From: Simon Davis <Simon.Davis@arun.gov.uk>
Sent: 11 August 2020 10:46
To: Planning.Responses <Planning.Responses@arun.gov.uk>
Subject: FW: Tars Farm, Barnham - Ref. BN/39/20/PL

Further Ecology comments

Subject: Tars Farm, Barnham - Ref. BN/39/20/PL

drawing				
ELEVATIONS - Plot 1				
Sheet 1 of 4				
scale	date	job no.	dwg no.	rev.
1:100 @ A2	DEC. 18	1816	2.23	-

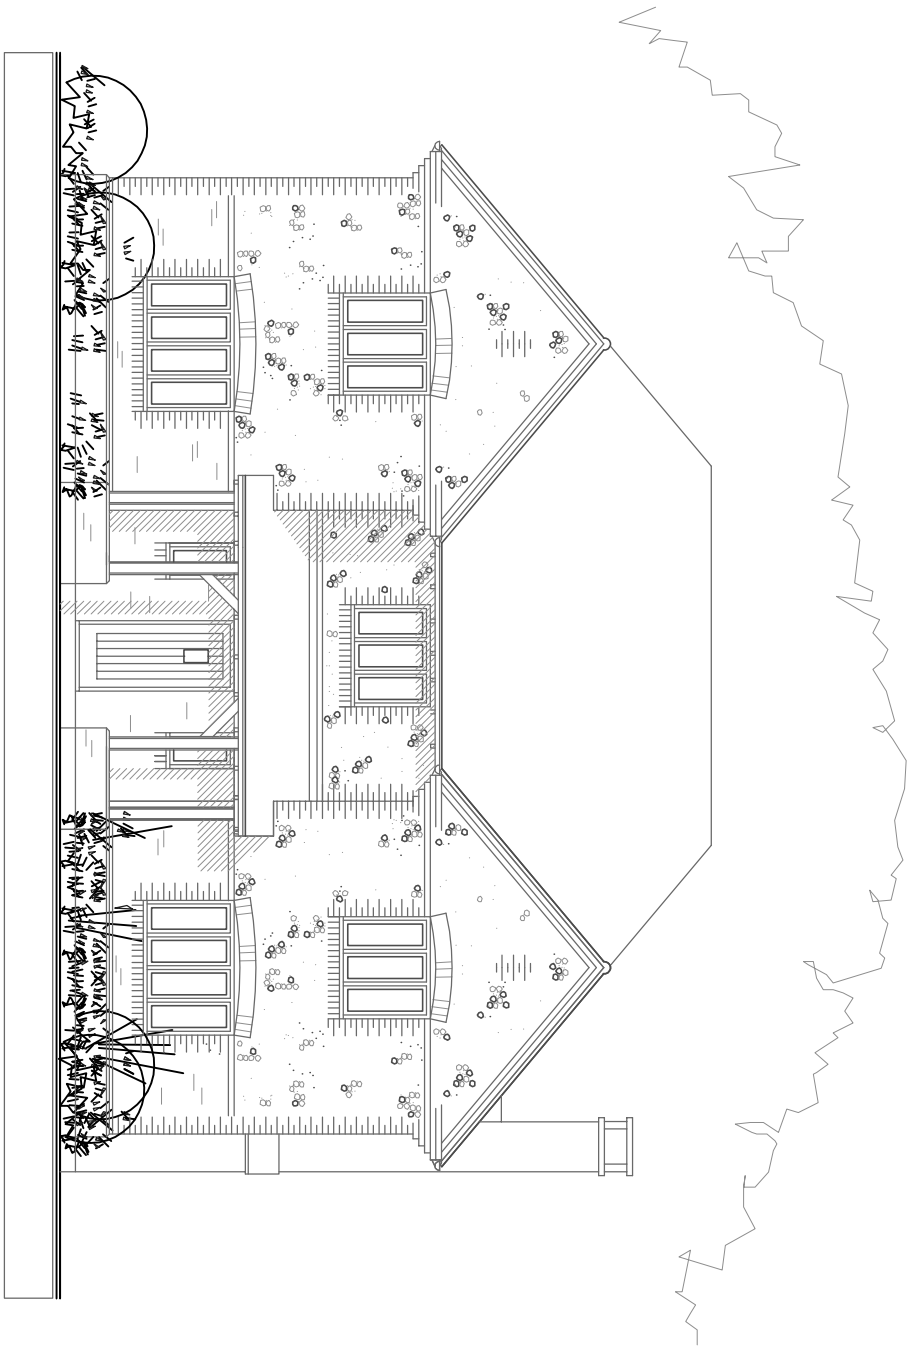
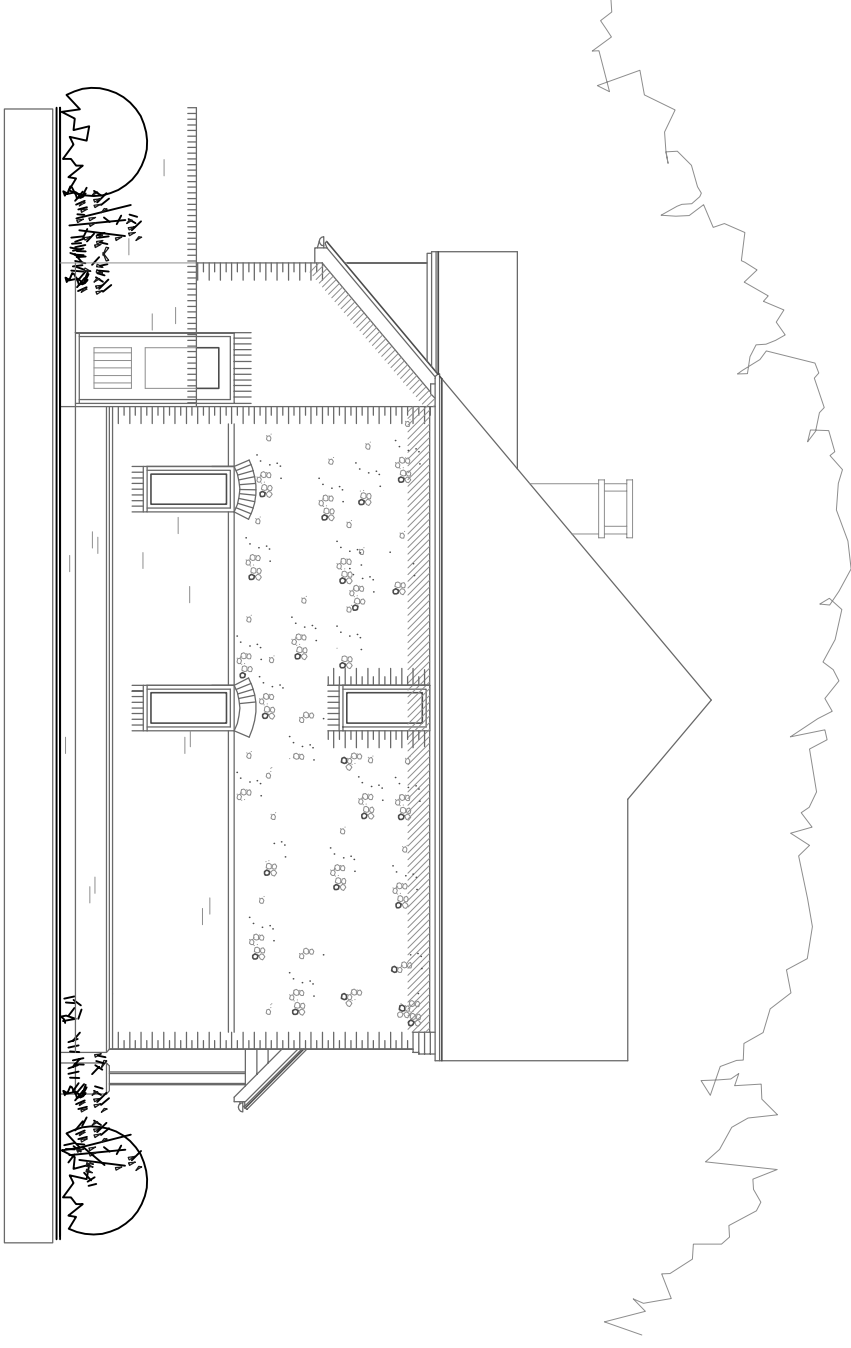
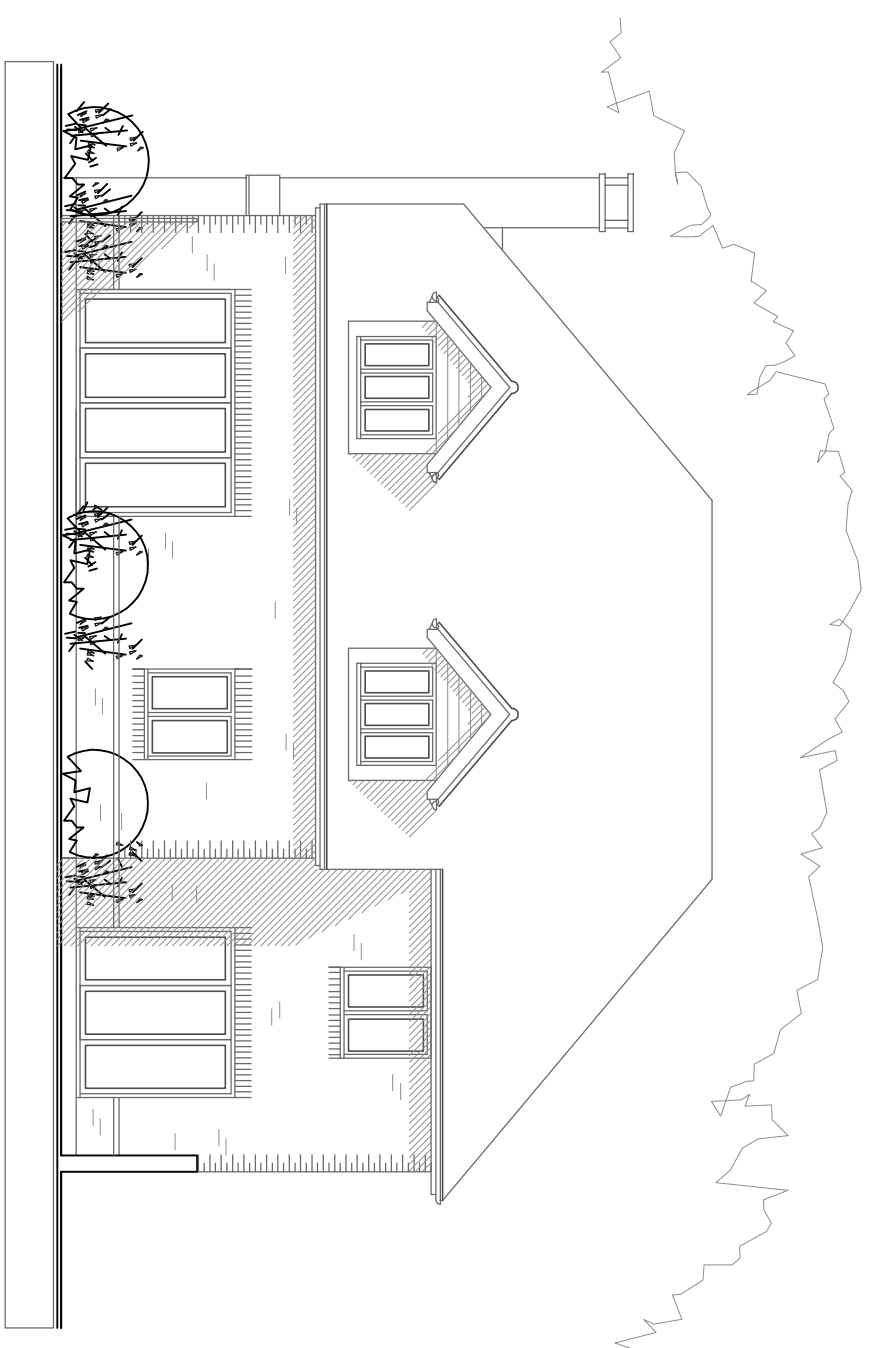
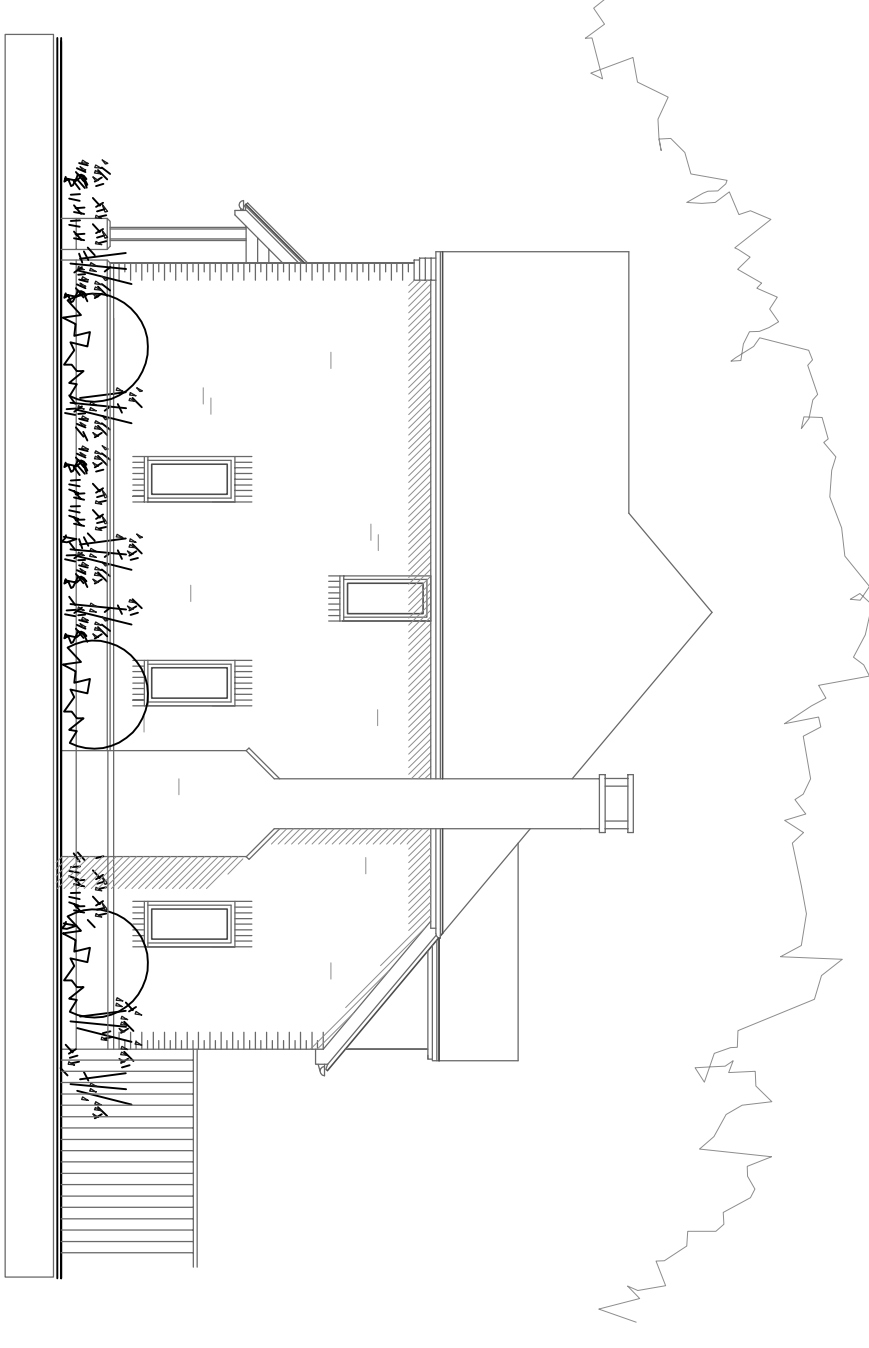
- *Bird box to be installed on the buildings / and or tree within the garden of the property – 1no. bird box installed on northern side of existing oak tree. Integrated Swift Box in the northern elevation of Plot 1 and integrated Sparrow Box in the northern elevation of Plot 2.*

ELEVATIONS - Plot 3

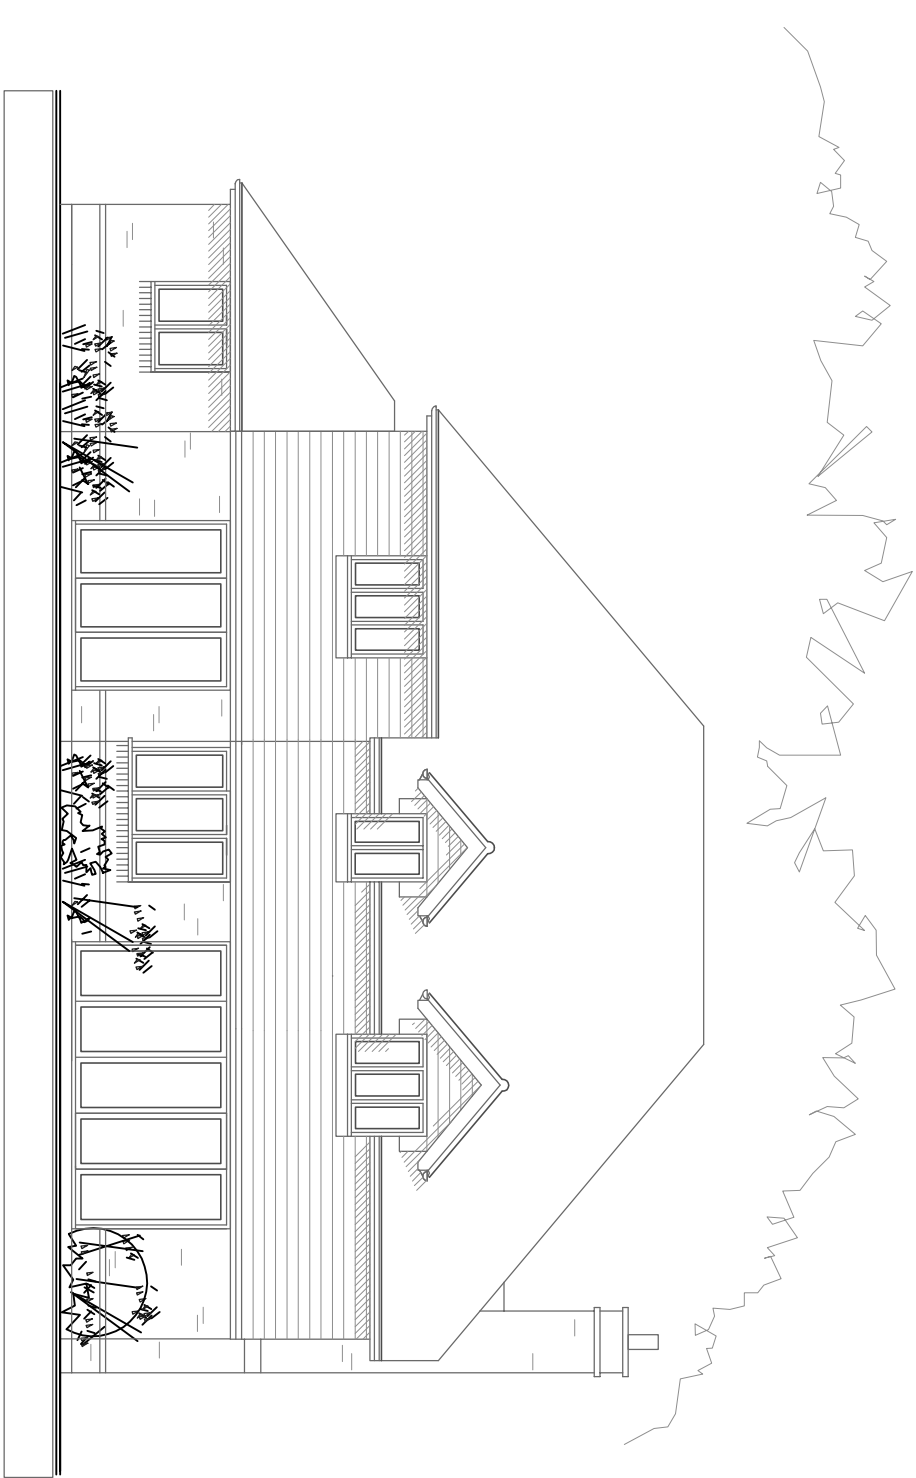
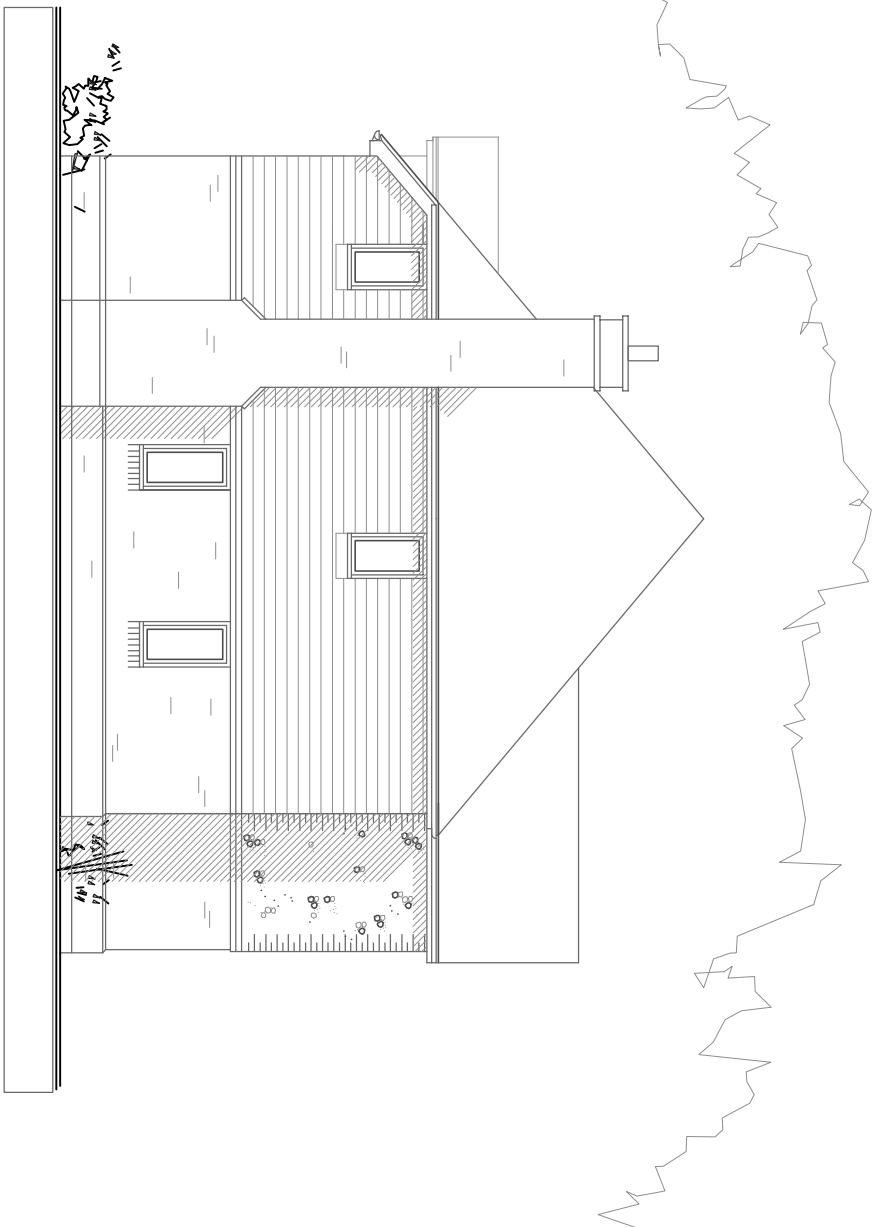
- *Bat bricks / tiles are integrated into the buildings onsite facing south/south westerly positioned 3-5m above ground – 1no. Integrated bat box installed in the southern elevation of Plot 3.*
